From: David Fuller [REDACTED]
Subject: Seahaven - EP/75/19/PL - Revised proposed scheme
Date: 21 October 2019 at 12:58:41 BST
To: Juan Baeza <juan.baeza@arun.gov.uk>, Zac Denton <zac.denton@arun.gov.uk>
[REDACTED]

You kindly agreed to look at revised drawings informally before we look to substitute them with the current proposals. Therefore I attach revised drawings for informal discussion which address the concerns as follows:

Elevations

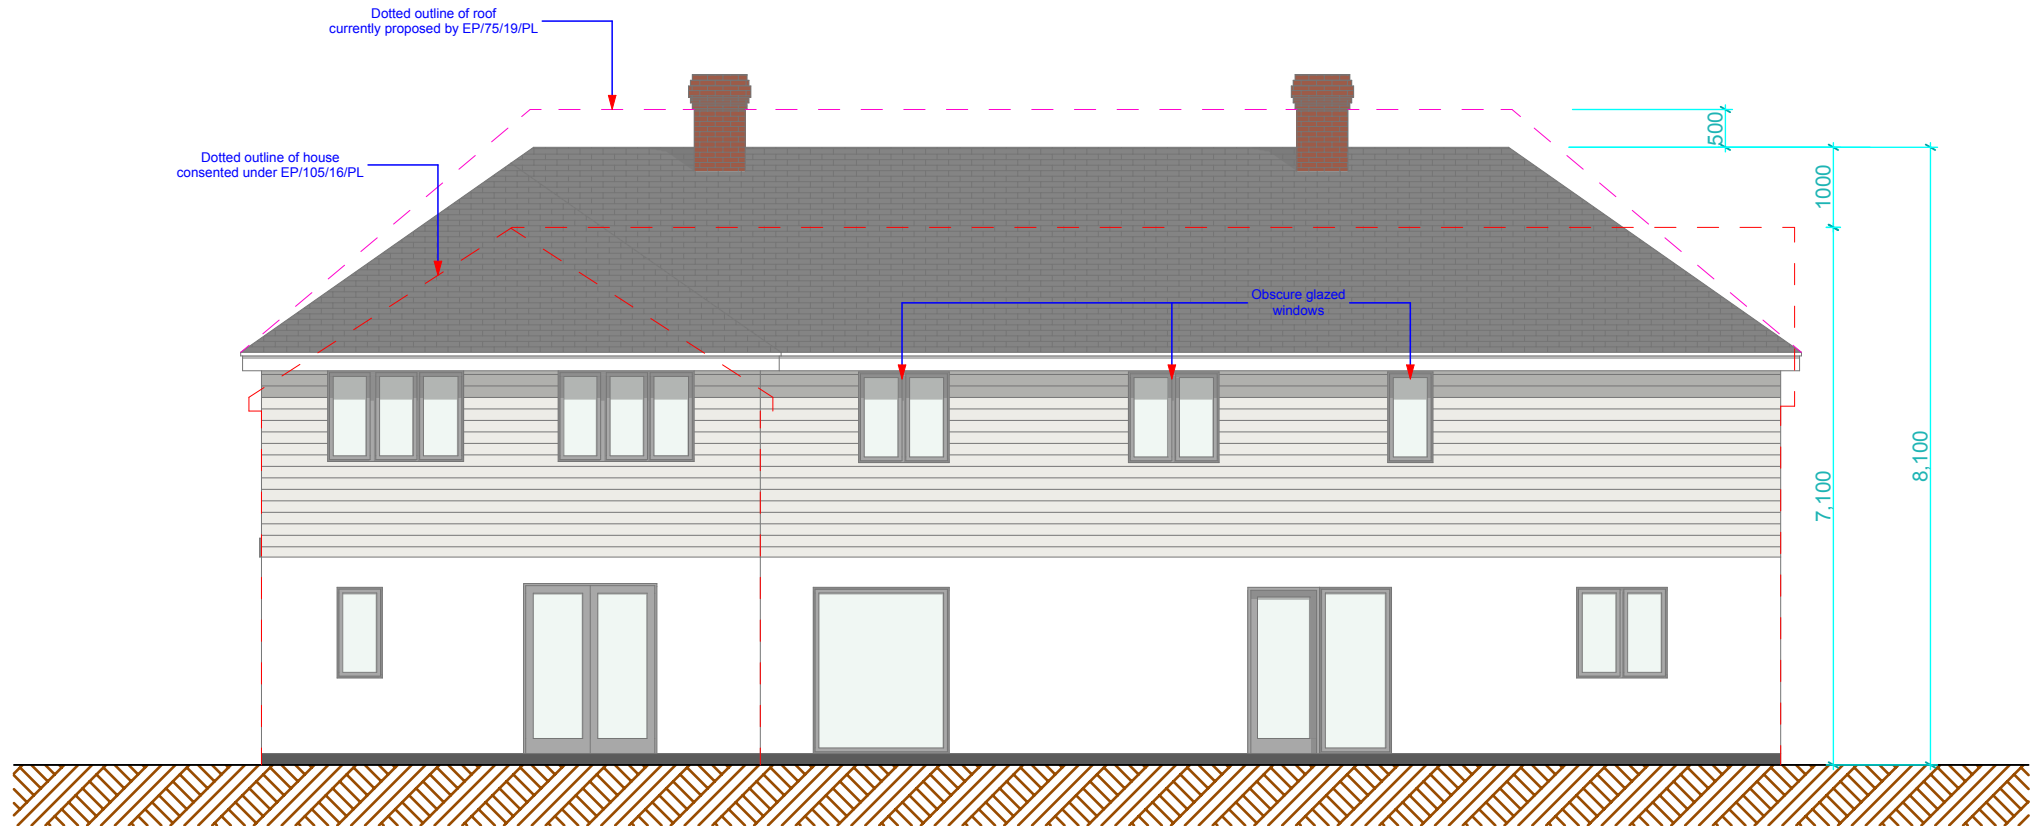
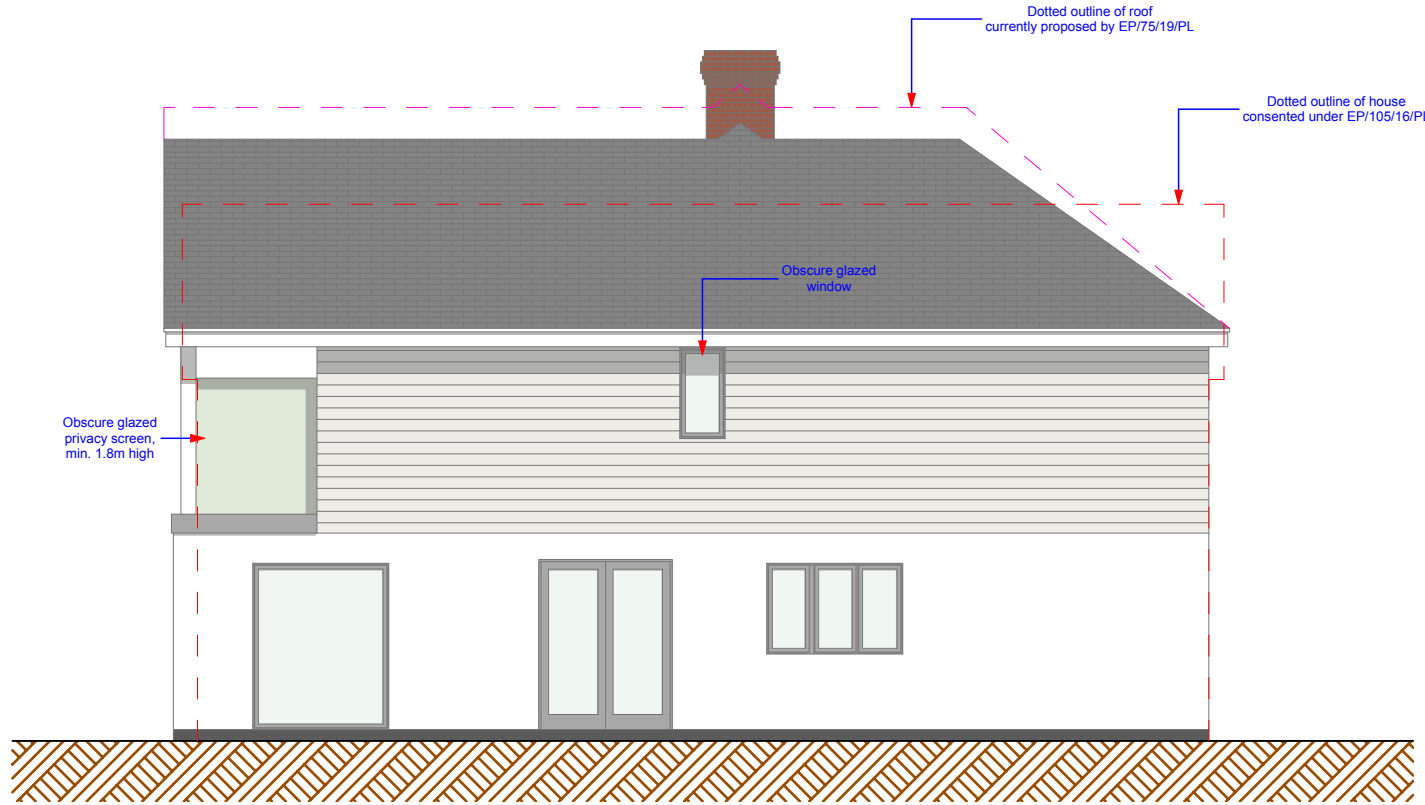
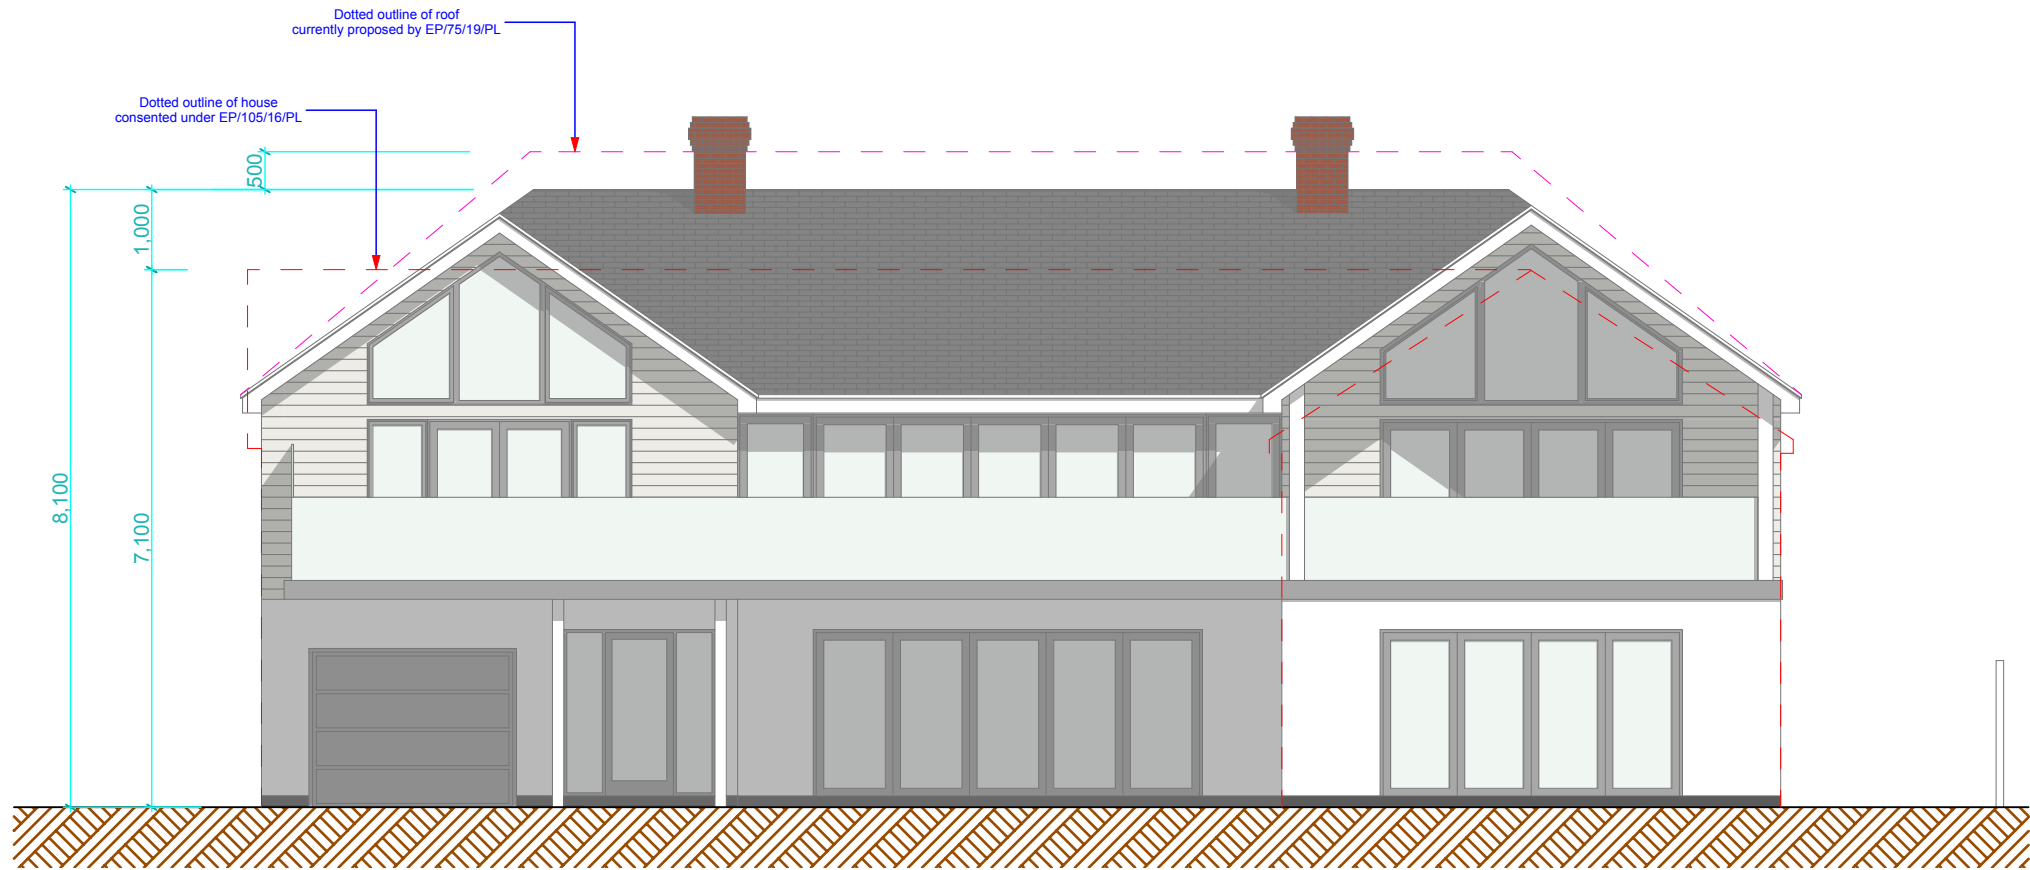
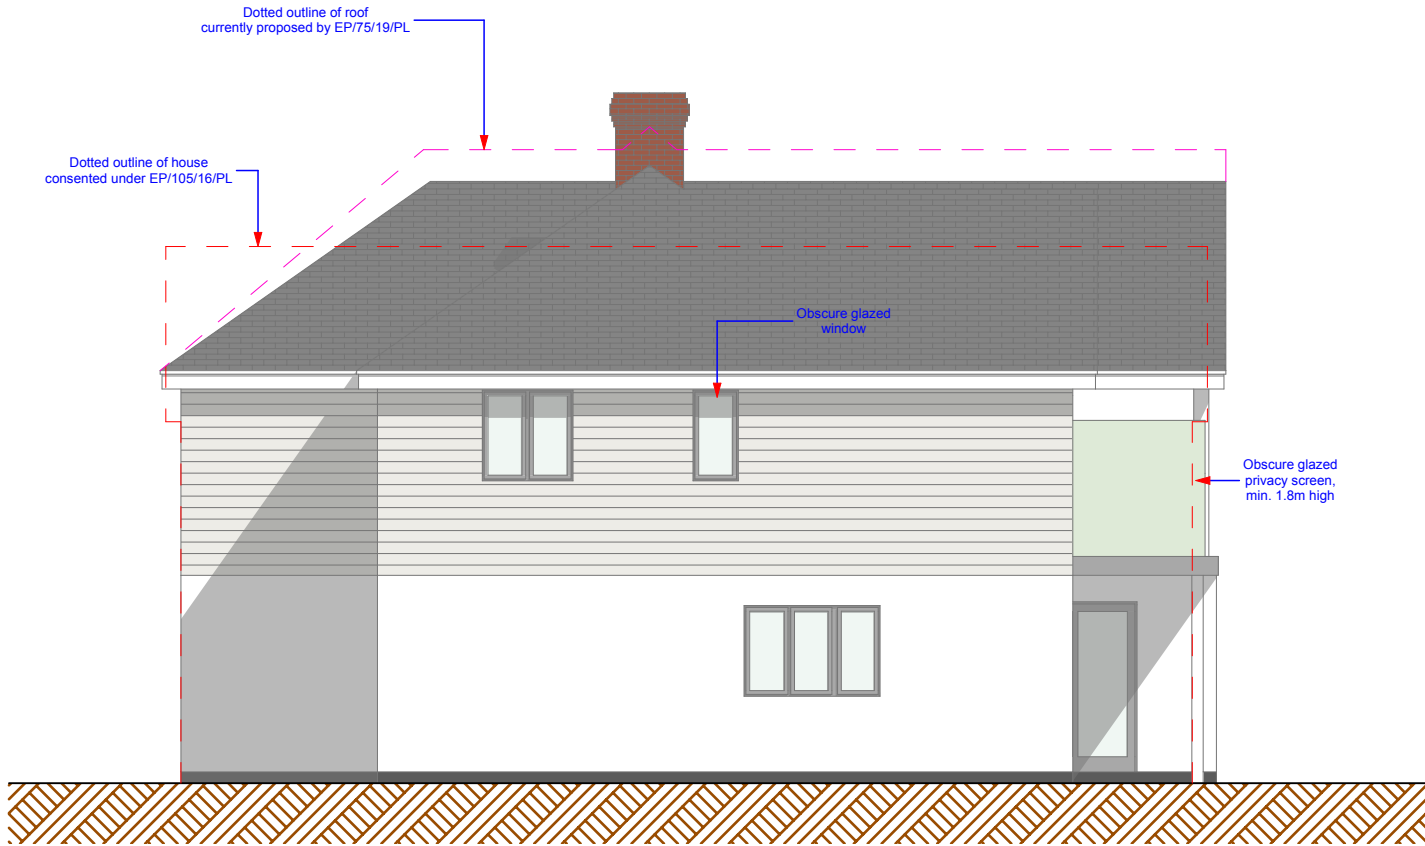
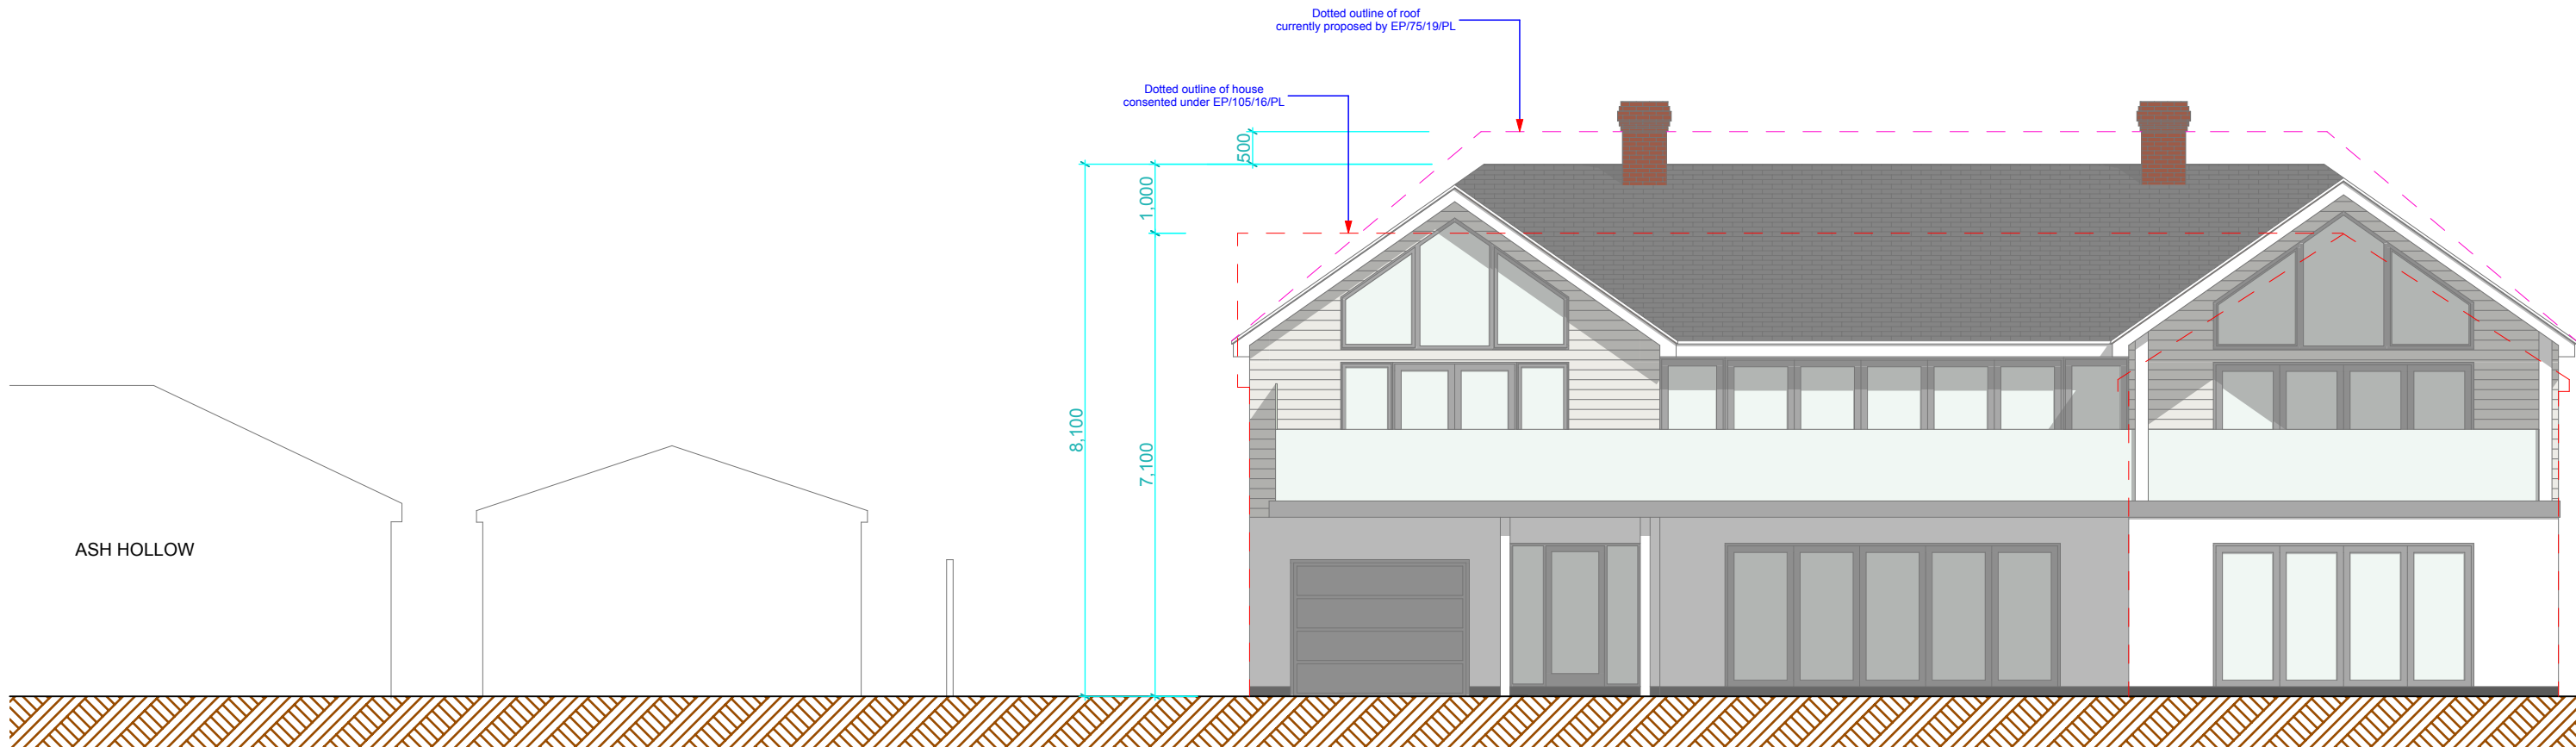
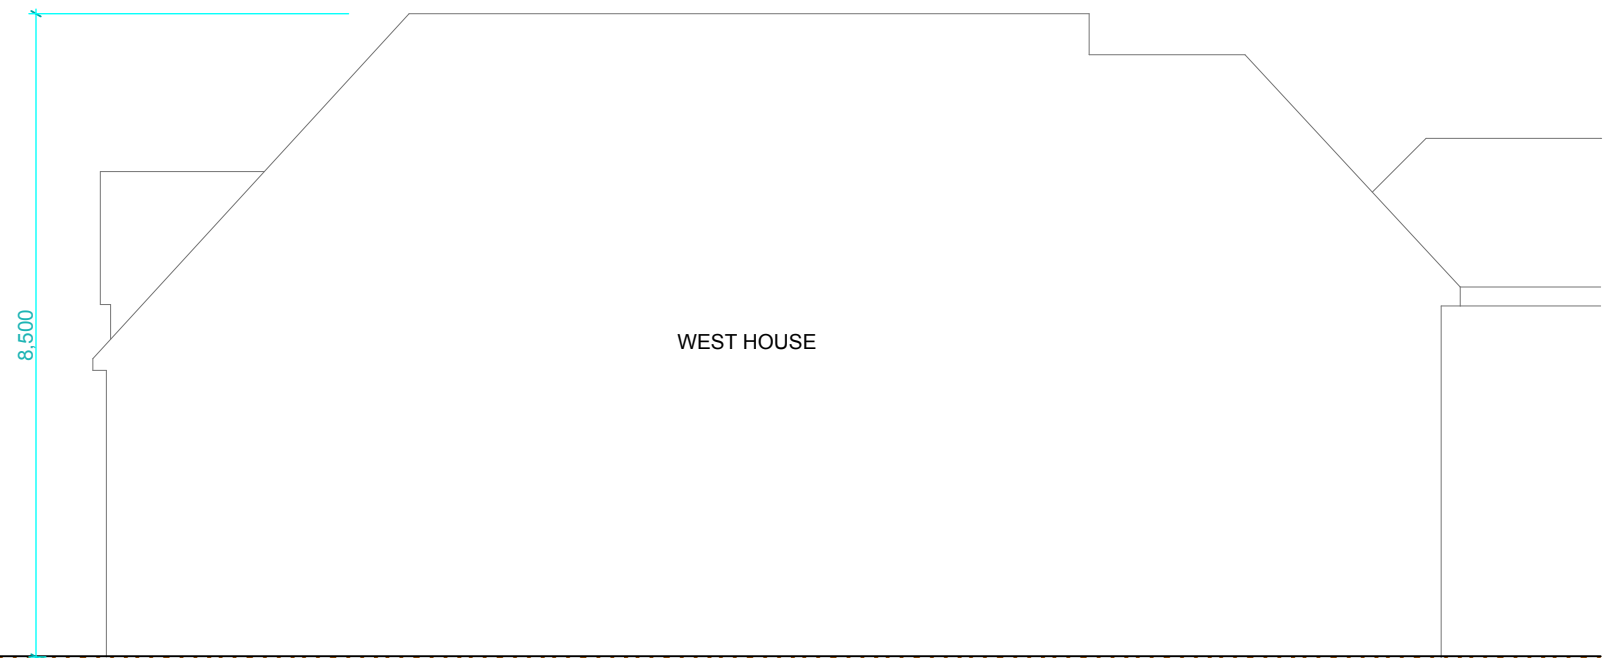
The current scheme proposes a revised roof design from what was consented under EP/105/16/PL, by omitting the gable ends to the North and East Elevations and incorporating hipped roofs instead. This results in the appearance of the roof mass being reduced to these elevations, as well as to the East side of the South Elevation. The triangular sections shown between the proposed hatched roofs and the dotted red outline on the attached elevations drawing depict this.

The overall roof pitch has been reduced from 40degrees to 35, and the result of this is a reduction in the ridge line and overall roof mass. The current scheme (outlined in magenta on the attached elevations drawing) proposed a ridge line 1.5m higher than the consented scheme (outlined in red on the elevations), however the revised scheme attached with the reduced roof pitch proposes an increase of just 1m from the consented scheme. Furthermore, the ridge of the revised proposed scheme is 0.5m lower than the ridge of the neighbouring property, West House to the East of Seahaven.
